From: Laura Gibbons
Sent: 05 March 2019 09:18
To: Planning.Responses
Cc: Michael Eastham
Subject: RE: Planning Consultation on BN/5/19/DOC

Engineers Comments Regarding Condition 5- surface water drainage

APPLICATION BN/5/19/DOC
NO:

Registered: 18-FEB-19
Site Address: Land at Former Pollards Nursery

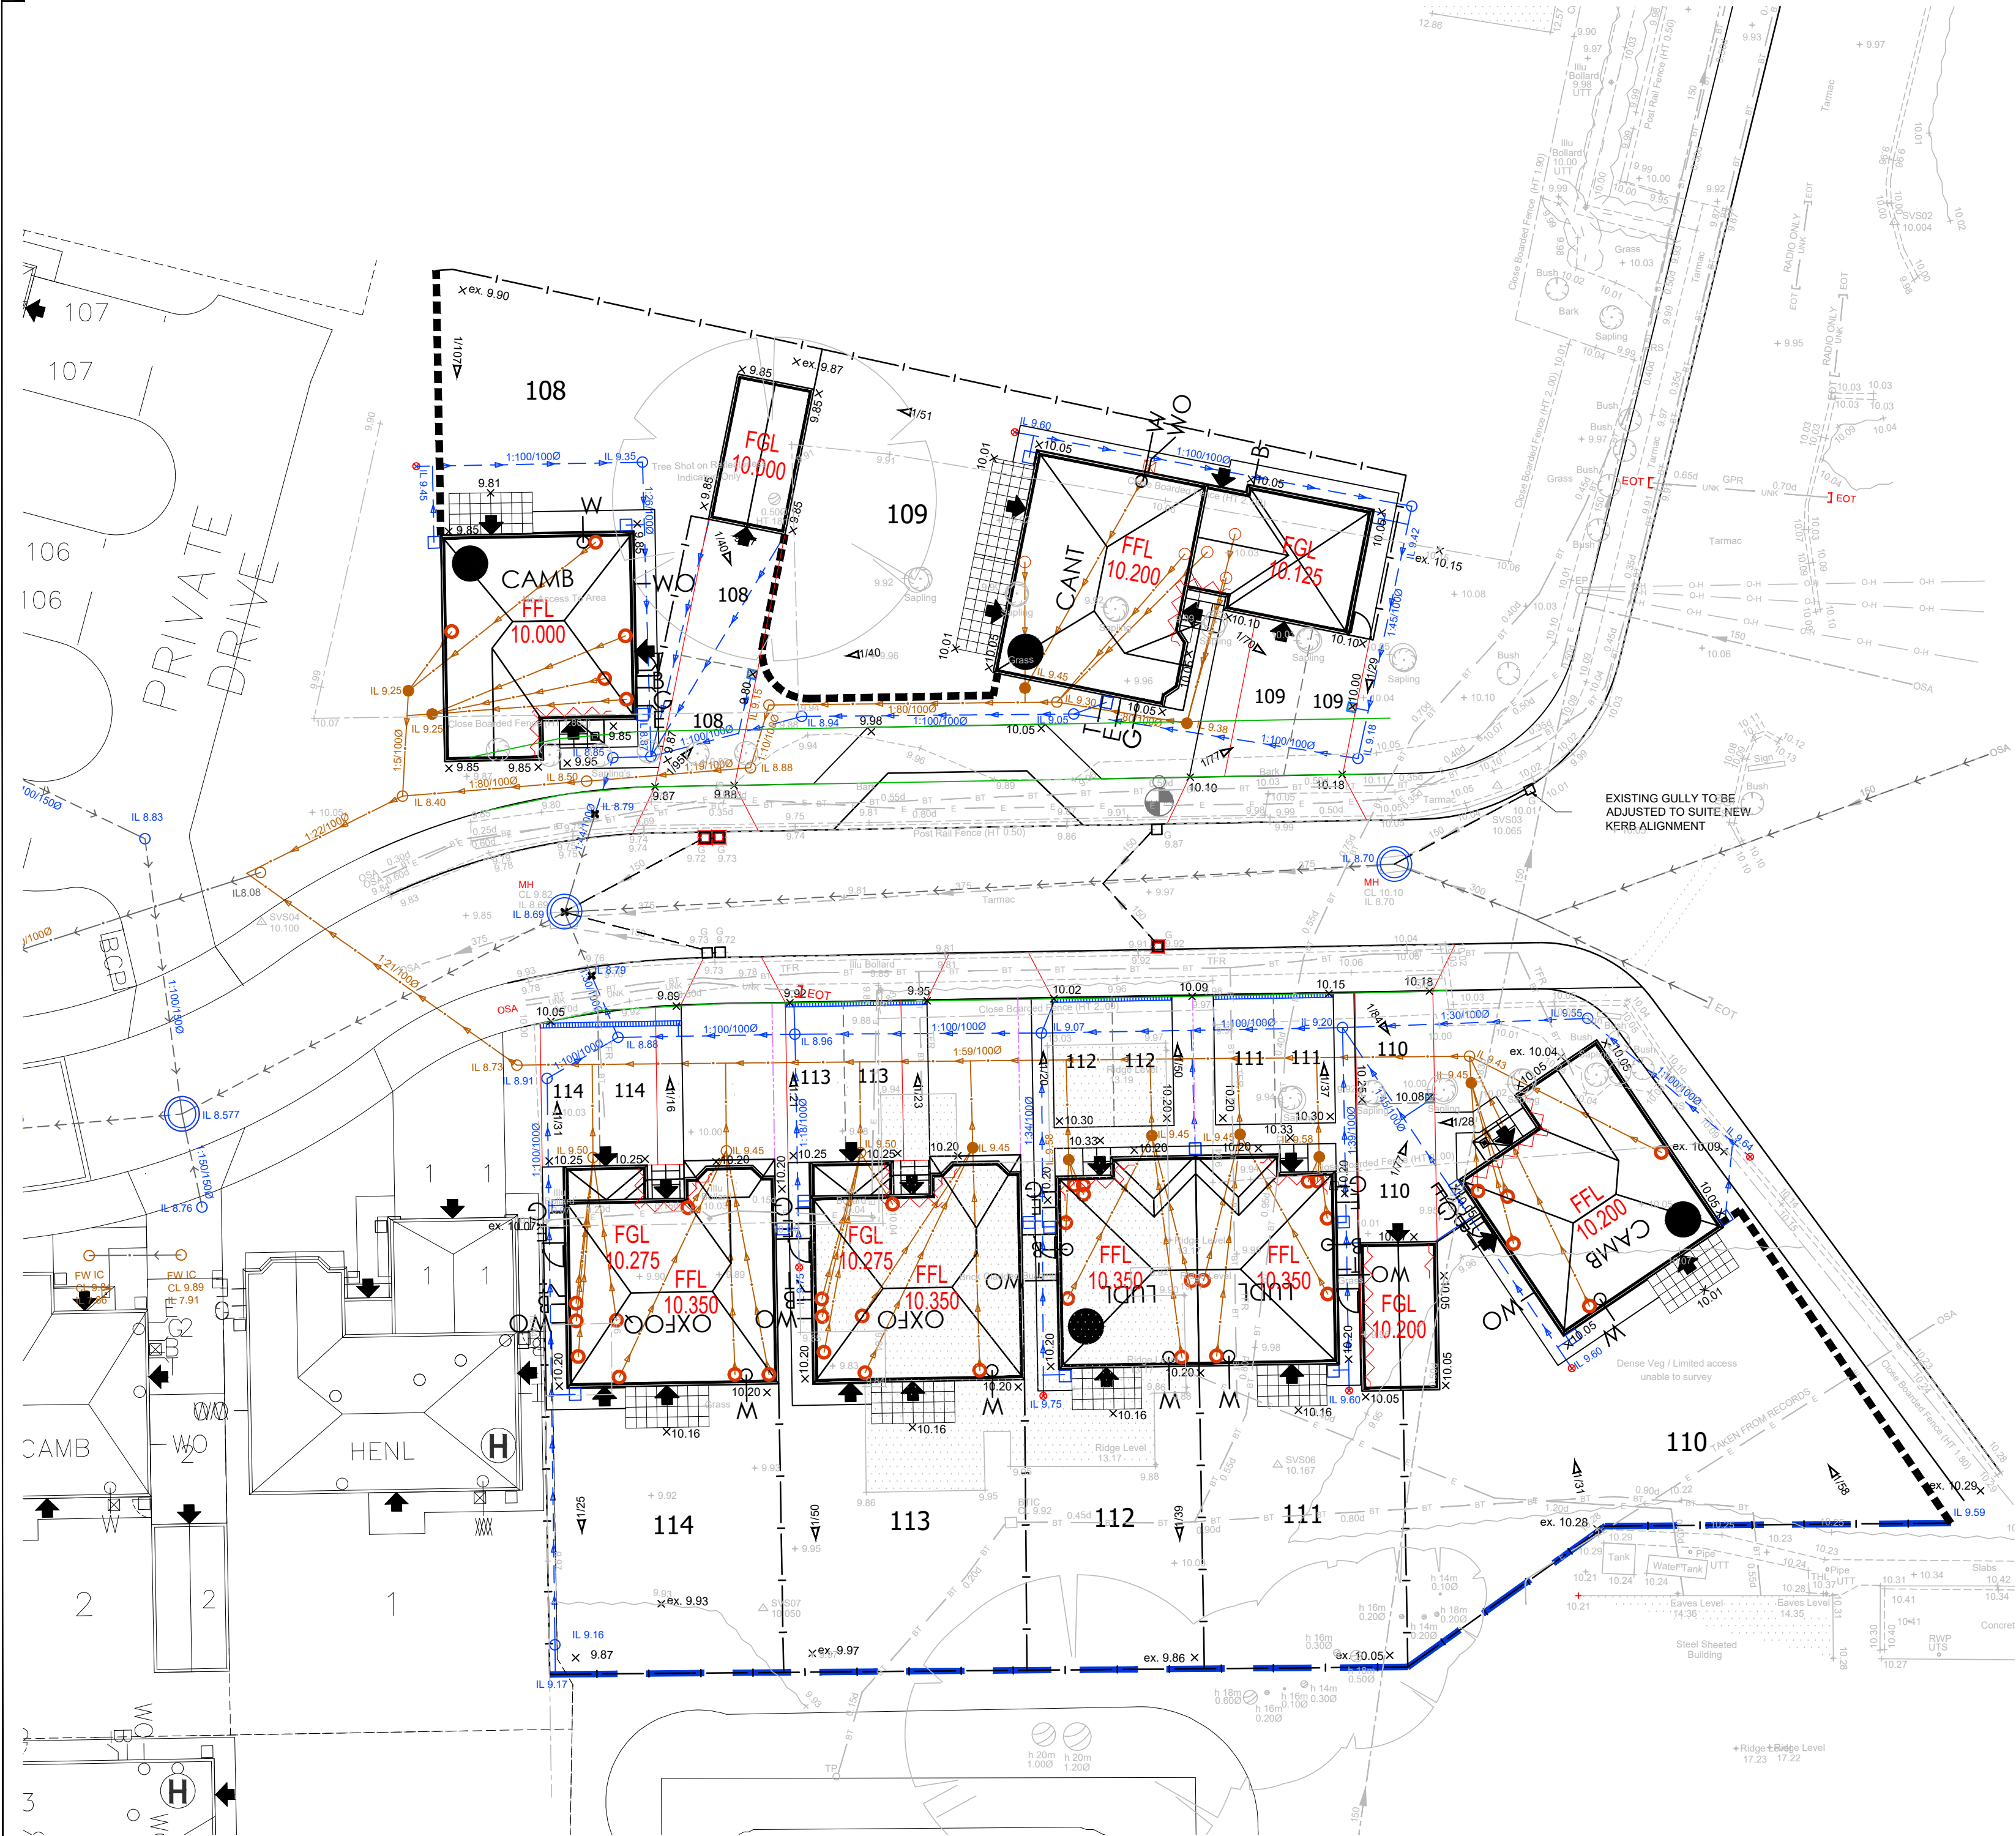
Plans have been submitted that show that the proposal is to connect the surface water drainage from this development into the existing site surface water drainage. However, no calculations etc. have been provided which demonstrate there is adequate capacity within the existing system to cope with these additional flows. Please can the applicant submit calculations which include the new and existing networks.
